PLANNING DEPARTMENT – Development & Building Services

RE: Dairy Queen at 6370 Coors NW – Grading & Drainage Plan for Building Permit
Bosque Plaza, Lot 6A P.E. Stamp: 8/7/12 (E12-D006A)

Based upon the information provided in your submittal received August 8, 2012, the above referenced plan cannot be approved for Grading and Building Permit until the following comments are addressed:

DAIRY QUEEN	DRAWN BY BJF
	GRADING AND DRAINAGE PLAN	DATE 12-29-05
	TIERRA WEST, LLC 8509 JEFFERSON NE ALBUQUERQUE, NEW MEXICO 87113 (505)858-3100	23141-GRB
		SHEET # C2
		JOB # 230141

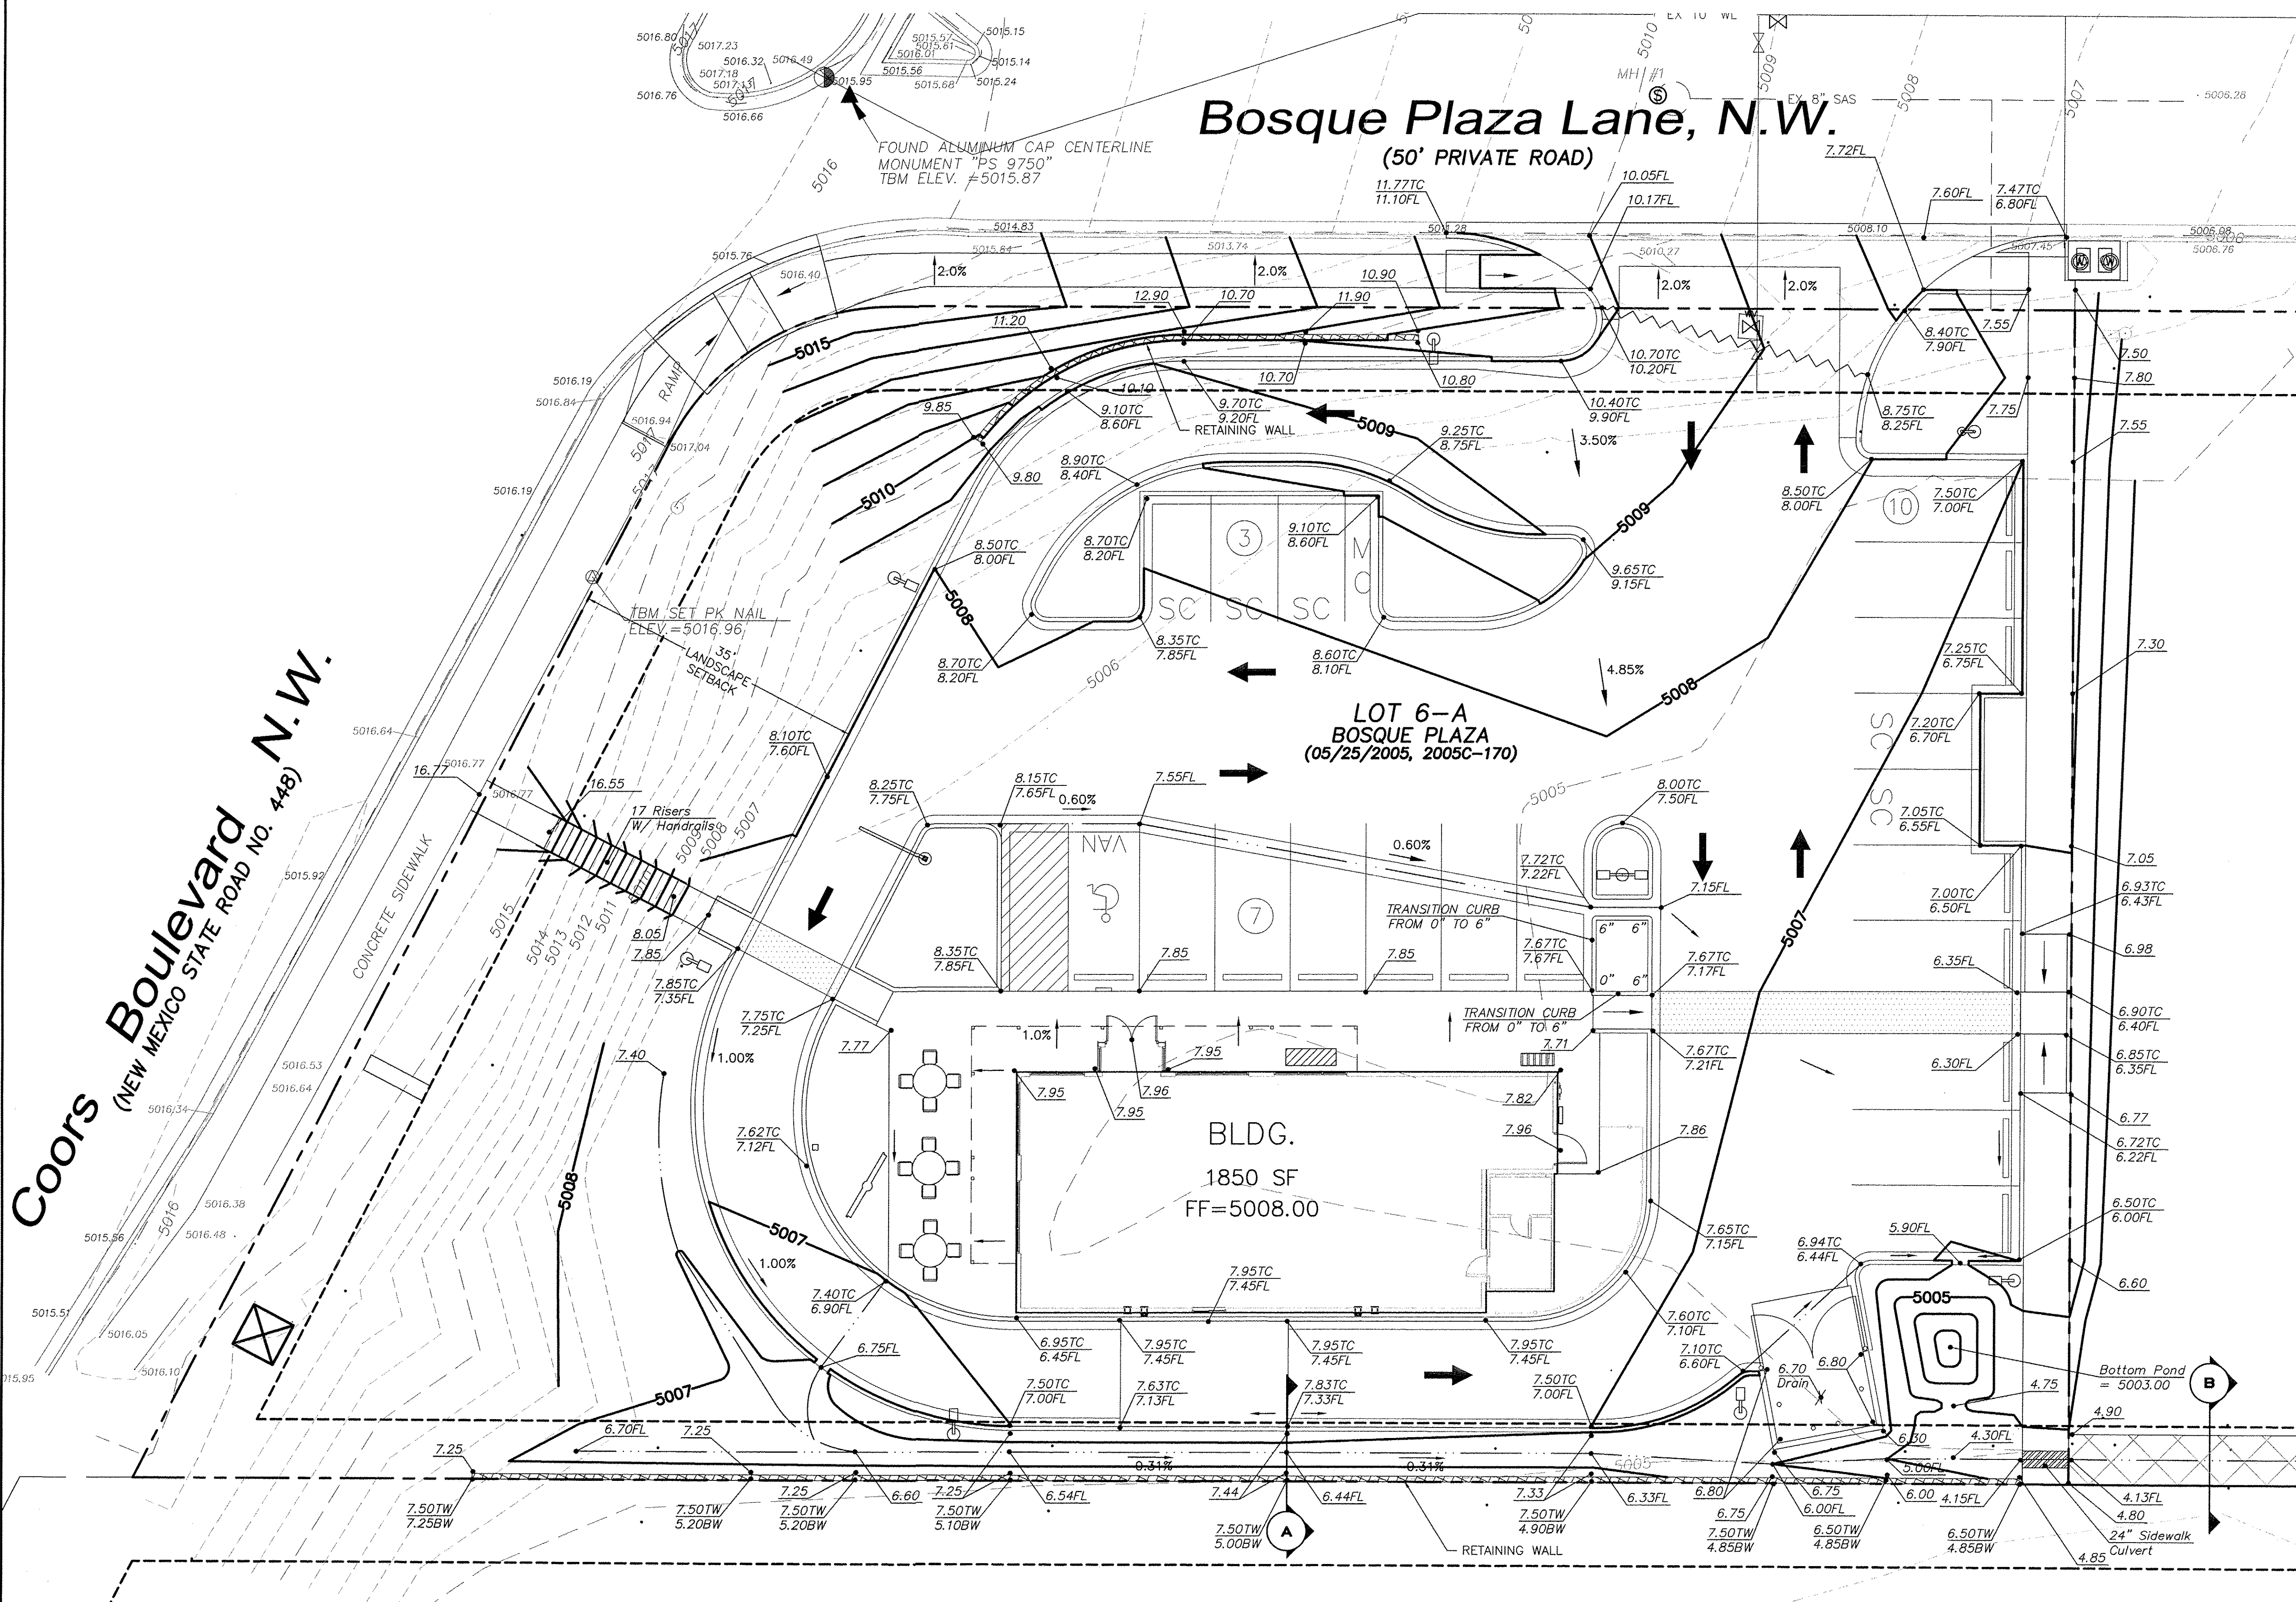
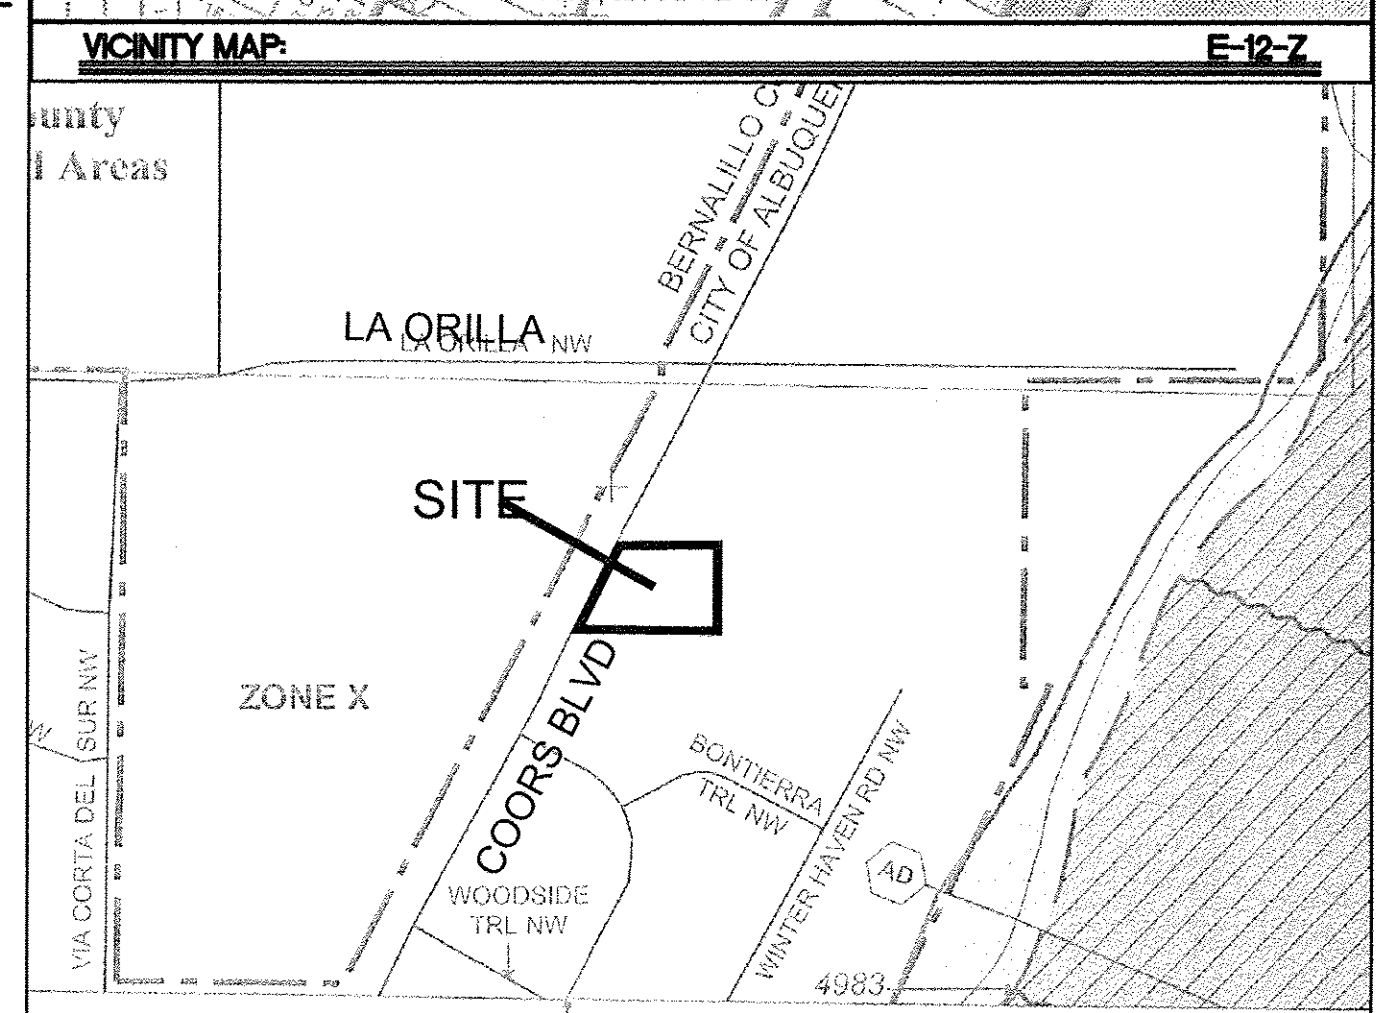
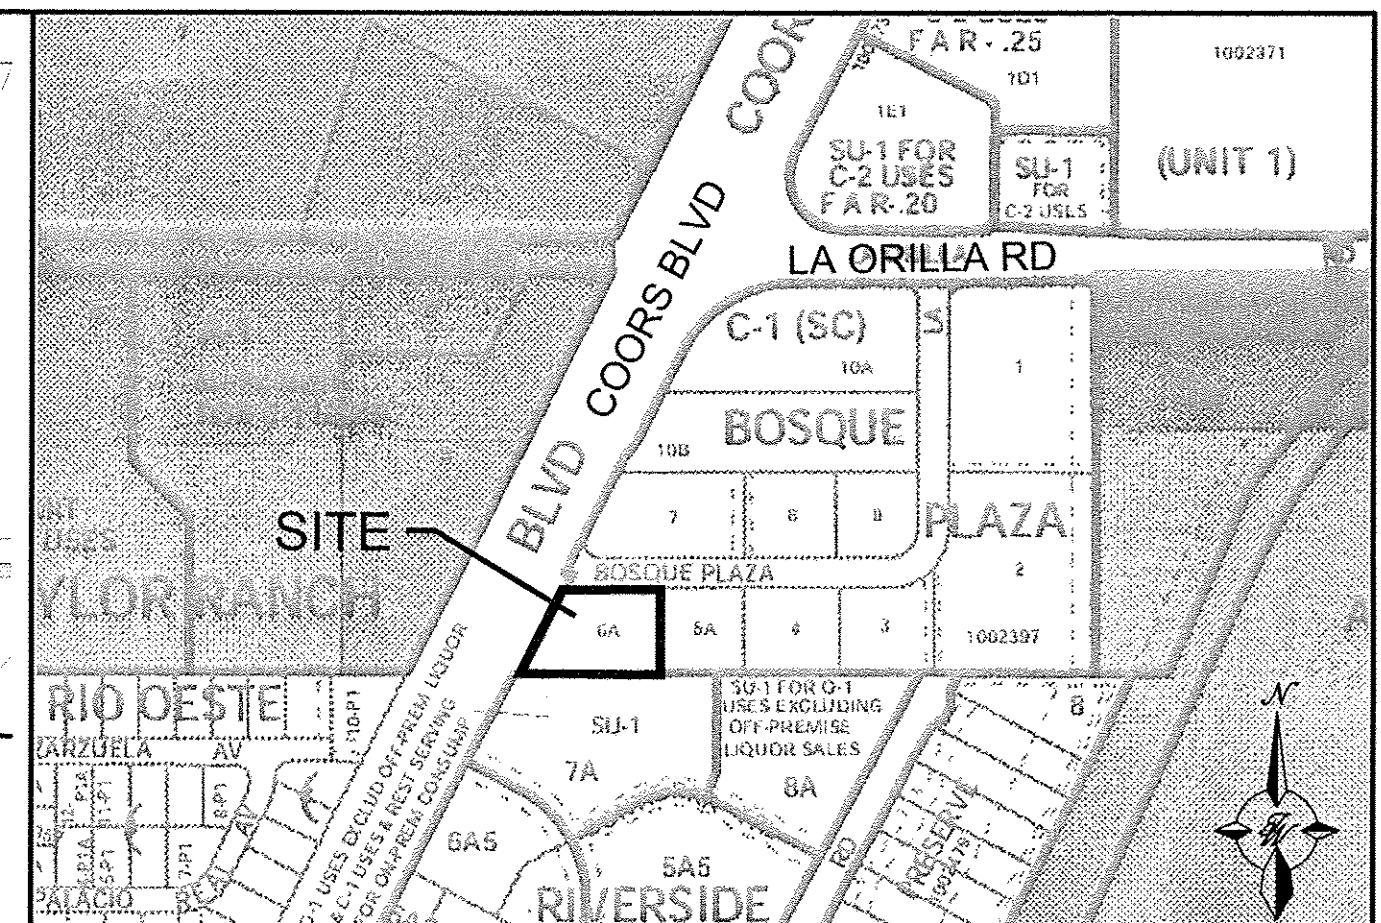
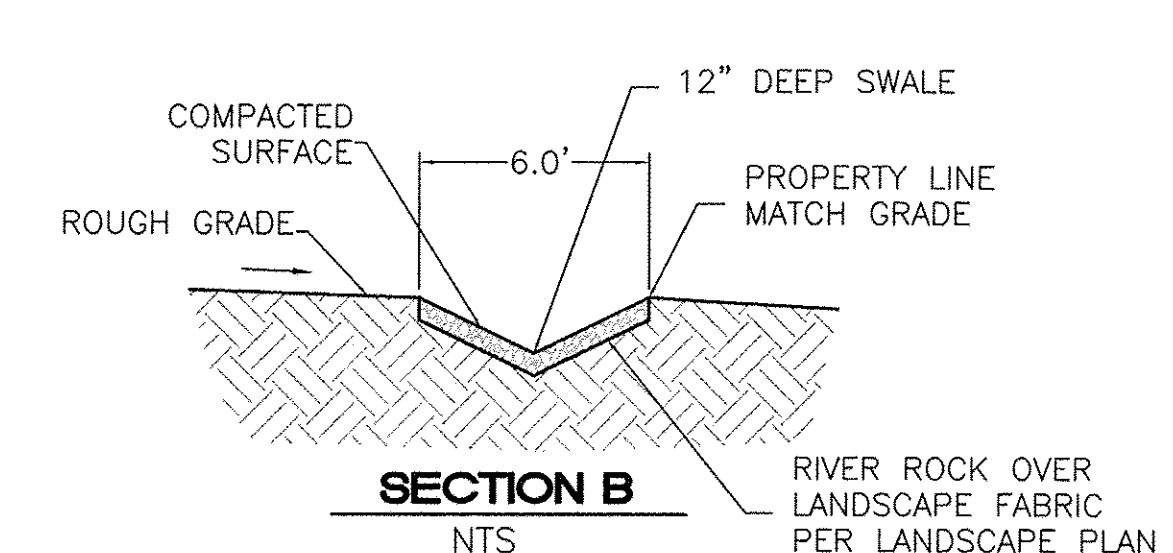
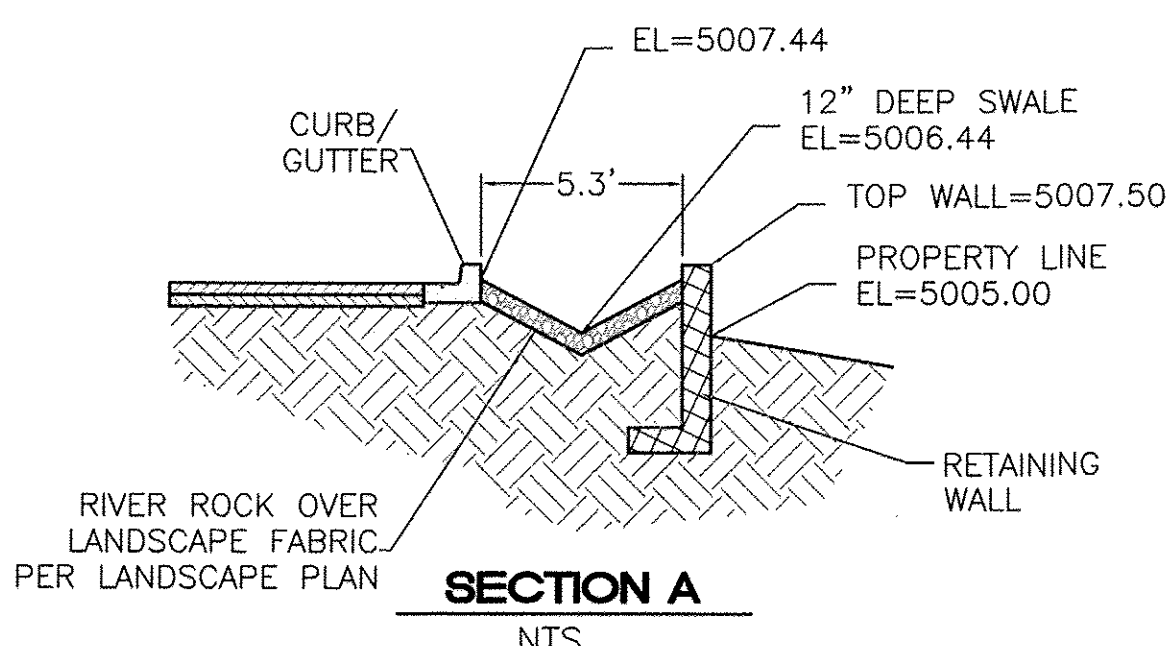
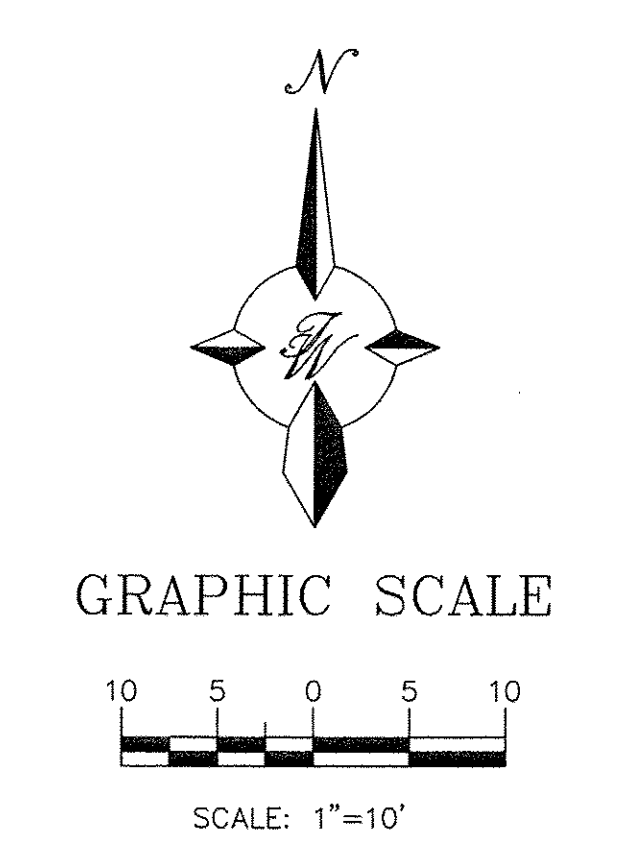
1. Sh. C2: Provide a call-out and width on each curb opening to water harvesting areas.
2. Sh. C2: Provide reference point on the detail for the Bottom of Wall grades shown on the plan (what is footing depth below BW grade?).

3. Sh. C2: Per the DPM Chapter 22 Section 9, runoff from the trash enclosure pad is required to drain to the sanitary sewer. Clarify that note on the Trash Enclosure pad drain.

4. Sh. C2: Label the Sidewalk along east property line.
5. Sh. C2/C2A: Plans call for grading and approximately 2' of fill along portions of the west edge of Tract 5A, as well as grading and channel improvements along the south and east sides of that Tract. Provide written confirmation of concurrence from the owner of Tract 5A, in support of the dated grading plan for this work.
